## **Application by Four Ashes Limited for an Order Granting Development Consent for the West Midlands Interchange**

### **The Examining Authority's written questions and requests for information (ExQ1)**

**Issued on 4 March 2019**

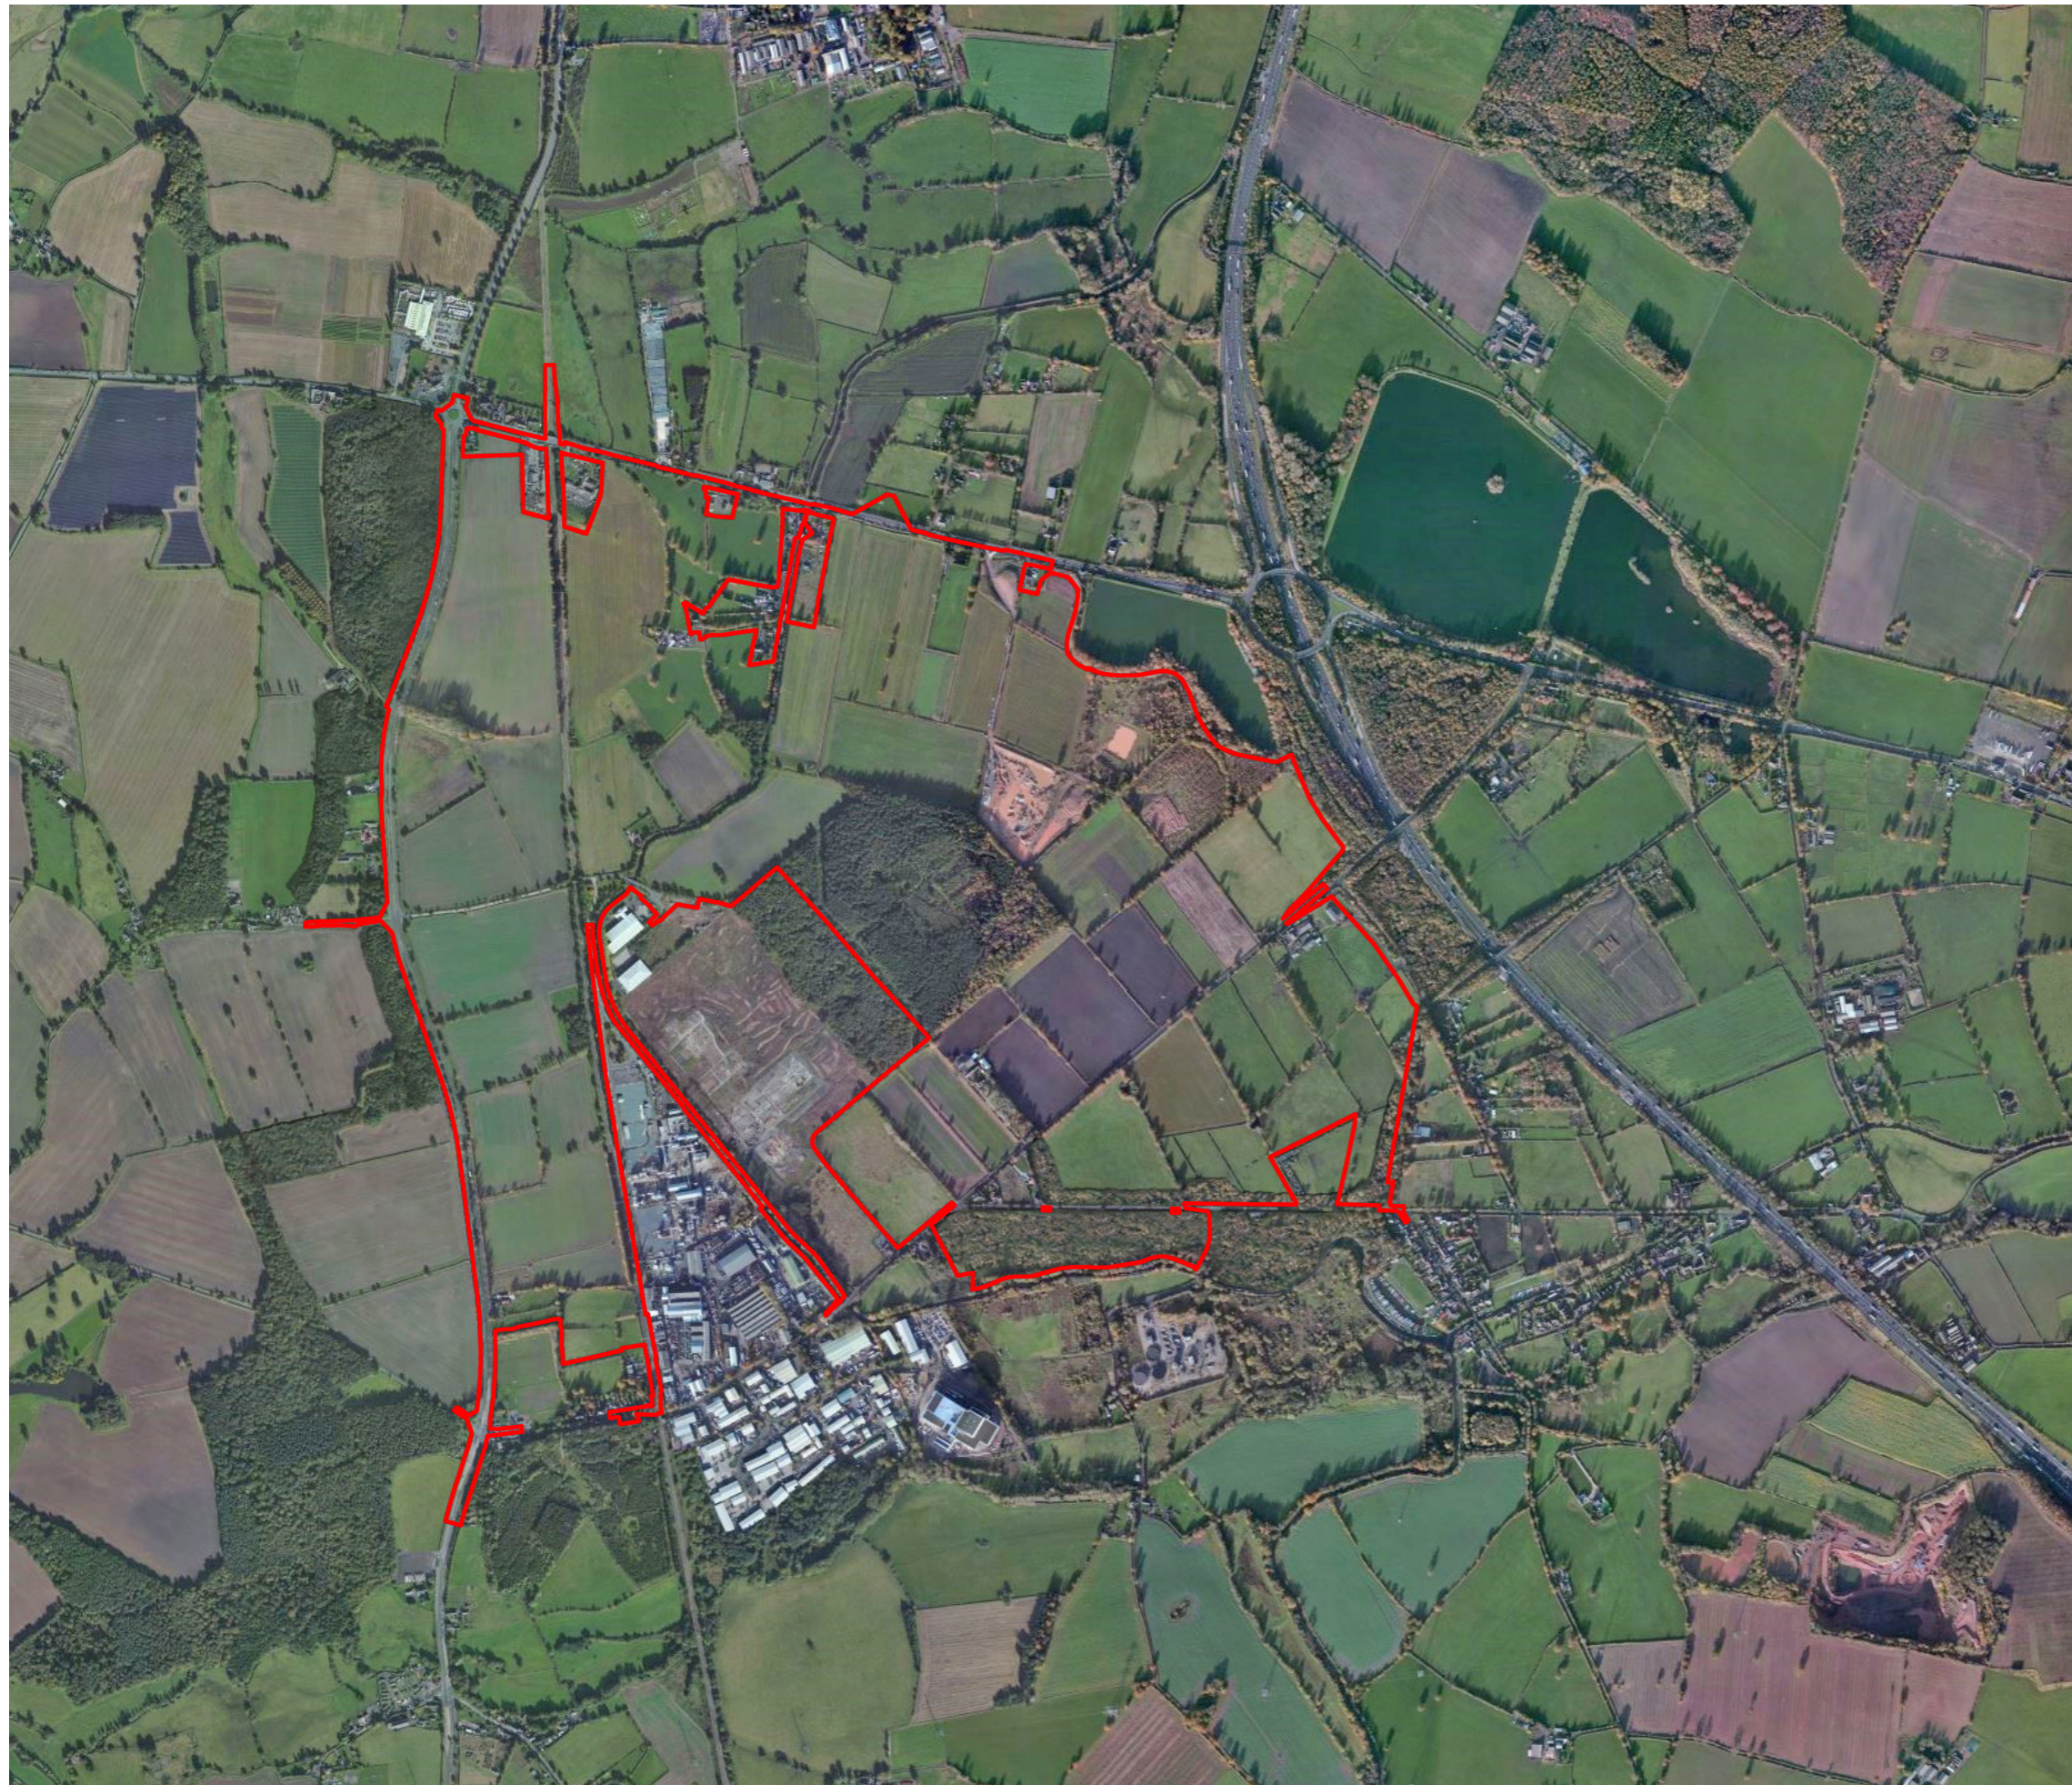
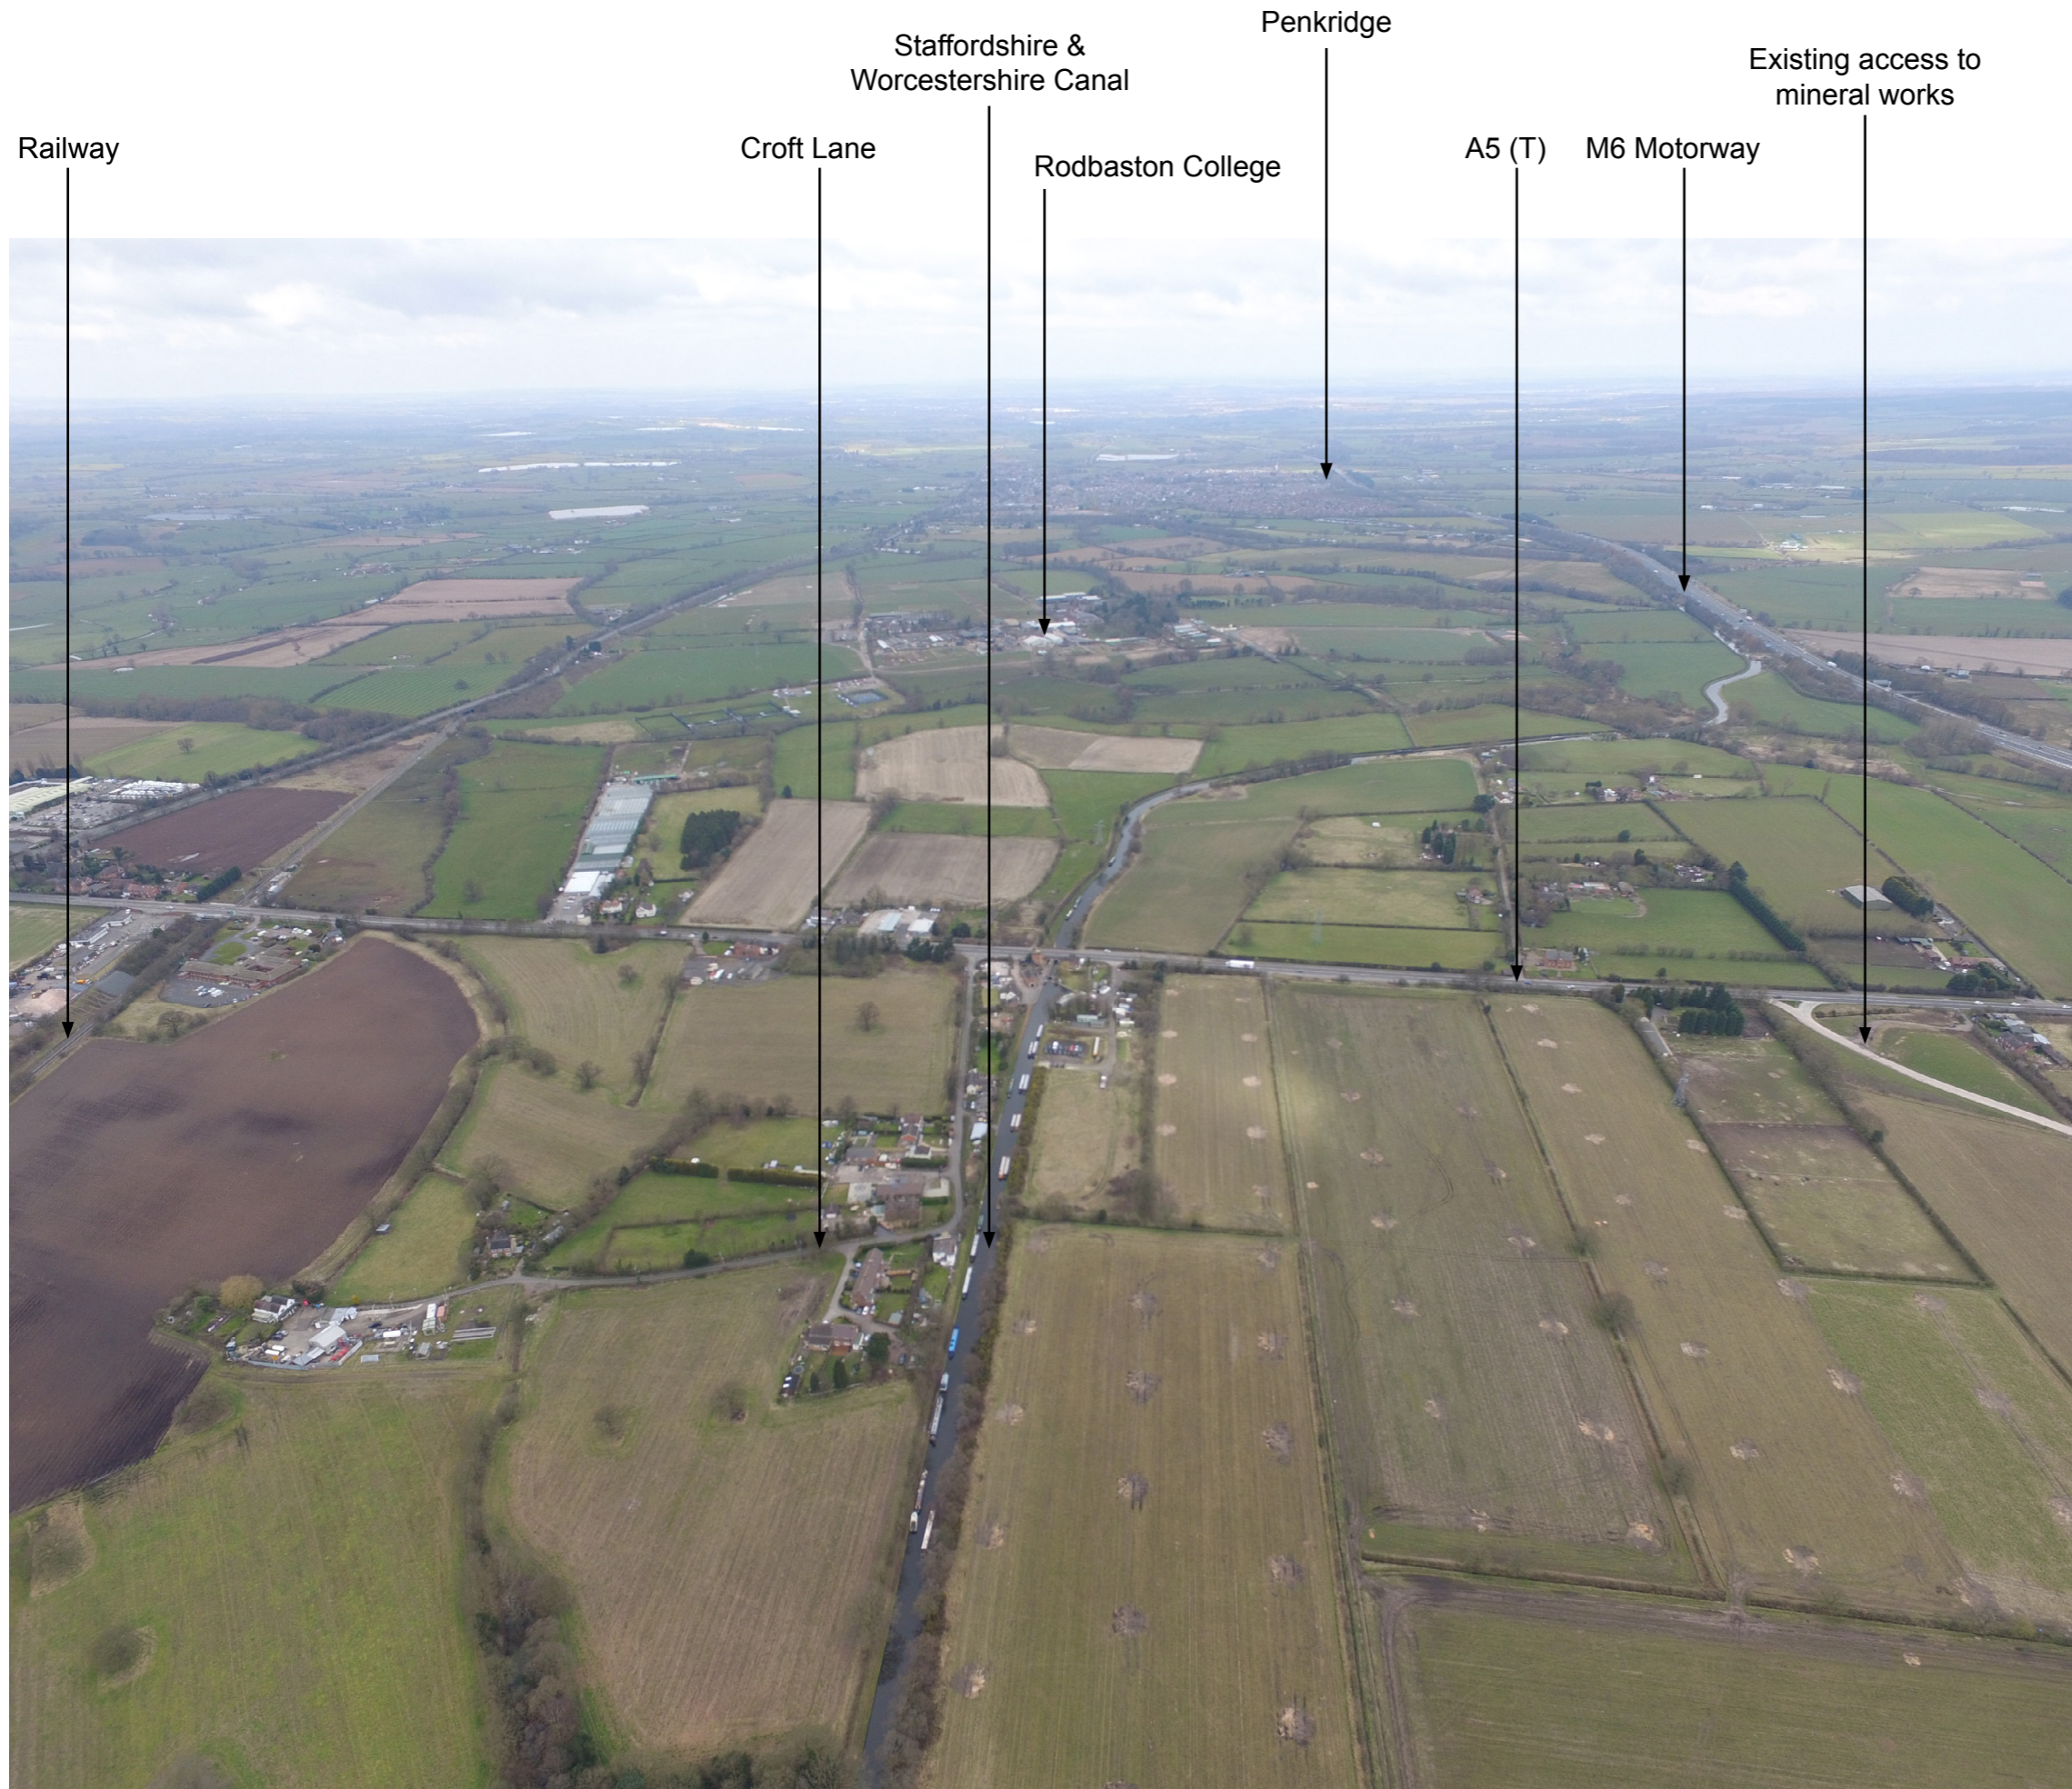
ExQ1	Question to:	Question:
1.0	<b>General and Cross-topic Questions</b>	
1.0.1	The Applicant and SSDC	<p><b>Existing Land Uses.</b>          Some of the base plans used in the submission include the notation 'Caravan Park' on land to the west of Croft Lane. This use is not evident on the aerial photographs in ES Figure 12.6 and does not appear to have been referenced or considered in the ES.</p> <p>(i) Does the use still exist and, if so, does it include any permanent residential use?</p> <p>Yes the current position is that planning permission was granted in 7.2.1961 (for 6 caravans) and 26.2.1963 for 3 additional caravans (copy enclosed of the site licence and planning permissions).</p> <p>In addition there is a planning permission in place under 18/00141/FUL for a mobile home. Copies of the 2018 permission and supporting reports can be supplied or can be viewed here - <a href="https://services.sstaffs.gov.uk/sscwebviewer">https://services.sstaffs.gov.uk/sscwebviewer</a></p> <p>Under the permission 18/00141/FUL, for retention of existing mobile home, the following condition was imposed:</p> <p><i>1. The mobile home hereby approved shall be removed from site within two months of it no longer being required to provide accommodation for the applicant's father, and shall thereafter be returned to grassland.</i></p> <p>In addition there is an extant site licence for 9 caravans to be stationed (in accordance with section 3 of the Caravan Sites &amp; Control of Development Act</p>

<p>1960).</p> <p>(ii) If not, is there a planning permission in place or other means by which such a use could be resumed or resurrected in this location and could this include any permanent residential use?</p> <p>See above</p>
